Consultation Response from KC, Lead Local Flood Authority
2023/93236 Pentlands, New Mill Road, Holmfirth, HD9 7LN
Discharge conditions 4 (Internal Estate Road Details), 5 (Parking Bay Surfacing & Drainage), 9 (Temporary Waste Measures), 11 (Surface Water Drainage Details), 12 (Overflow Event Scenario), 13 (Separate Forms of Drainage Details), 15 (Temporary Drainage Measures), 22 (Ecological Enhancement Plan) on previous permission 2020/91896 for demolition of existing dwelling and erection of 15 dwellings with associated access and external works
Date Responded: 12th March 2024 Responding Officer: Paul Farndale Responding Ref:

Condition 11 – Drainage Details

Note.
Manhole Covers and All Buidling Work to be done by others.

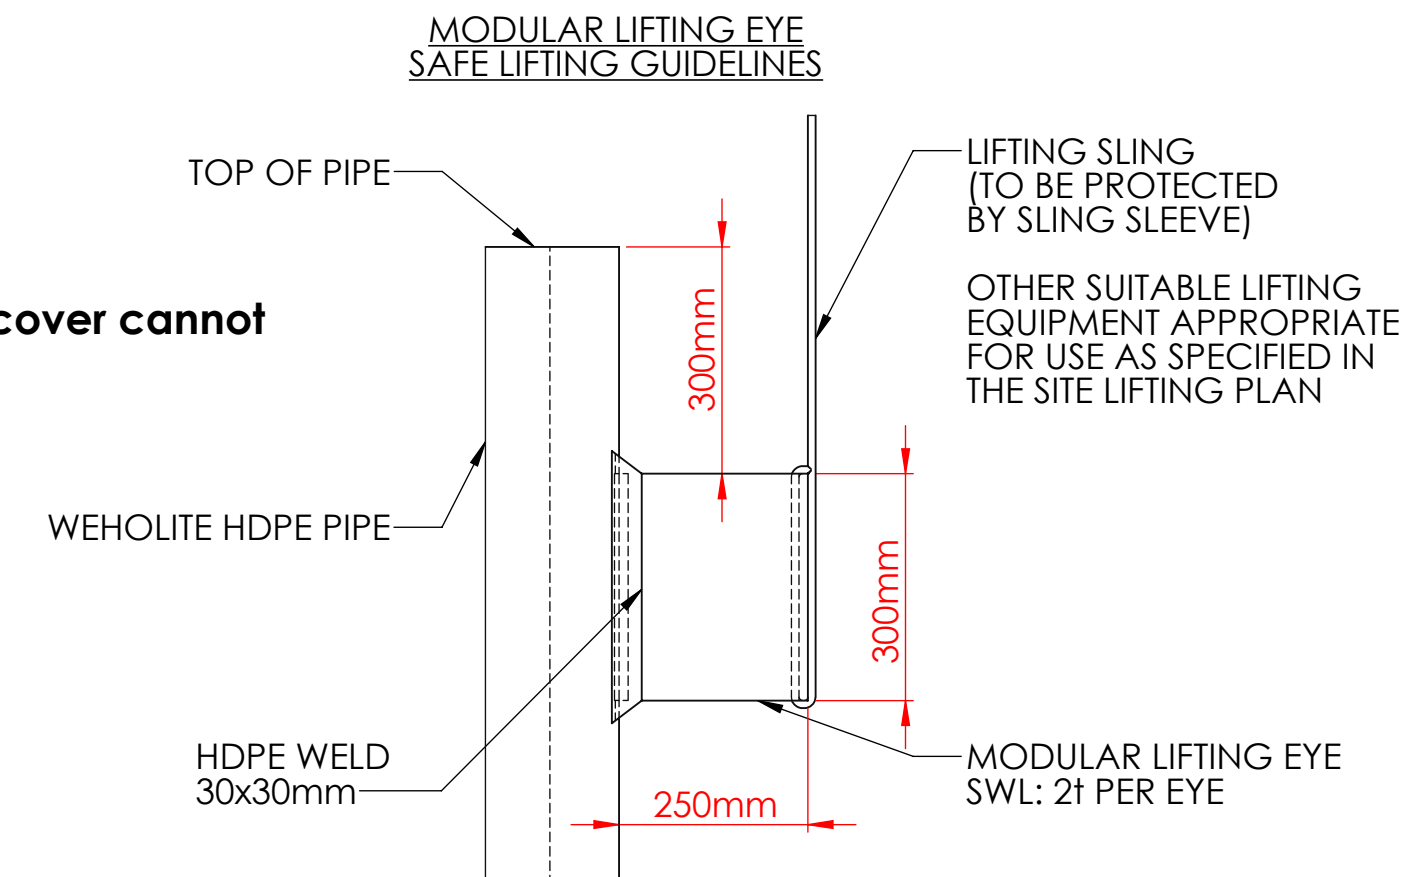
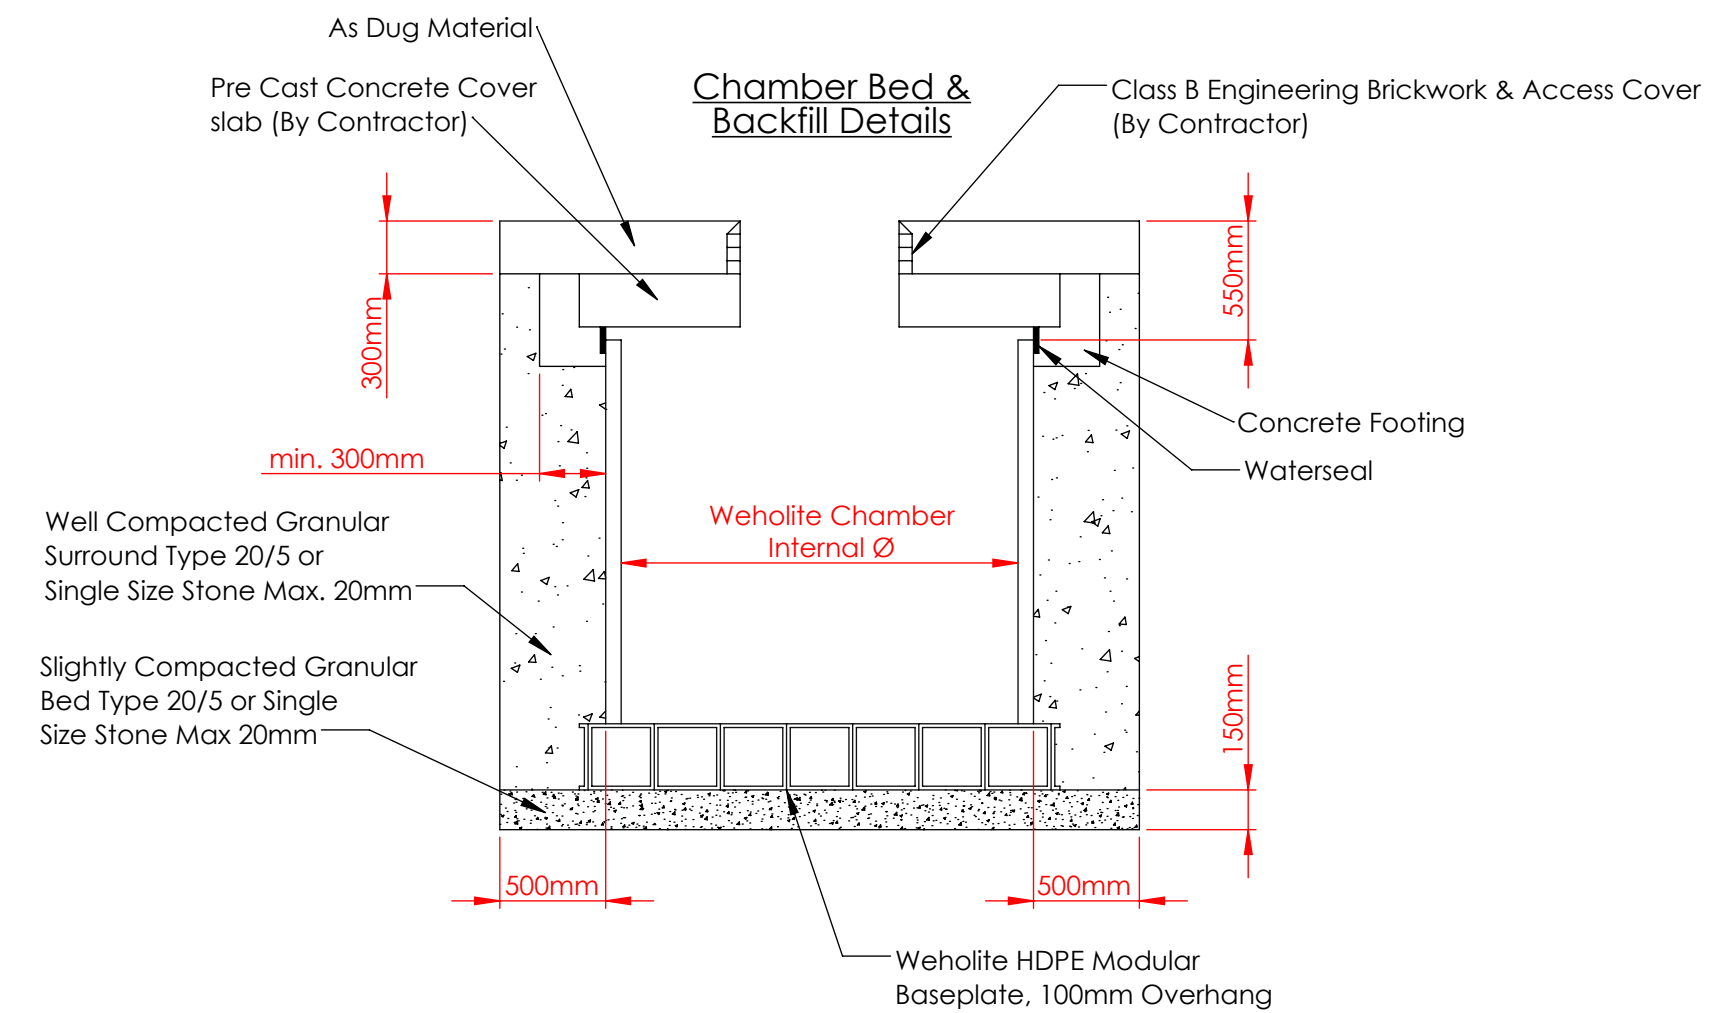
Details of the tank design including invert and cover levels has been provided. However, this is contrary to what was discussed for planning application 2020/91896 which allowed approval subject to condition. At this point the application went forward with pre-cast concrete tank having been agreed. This principle has been reneged upon

As an additional note, the calculations provided are for a different sized tank than submitted on the plan. No allowance for void ratio has been included.
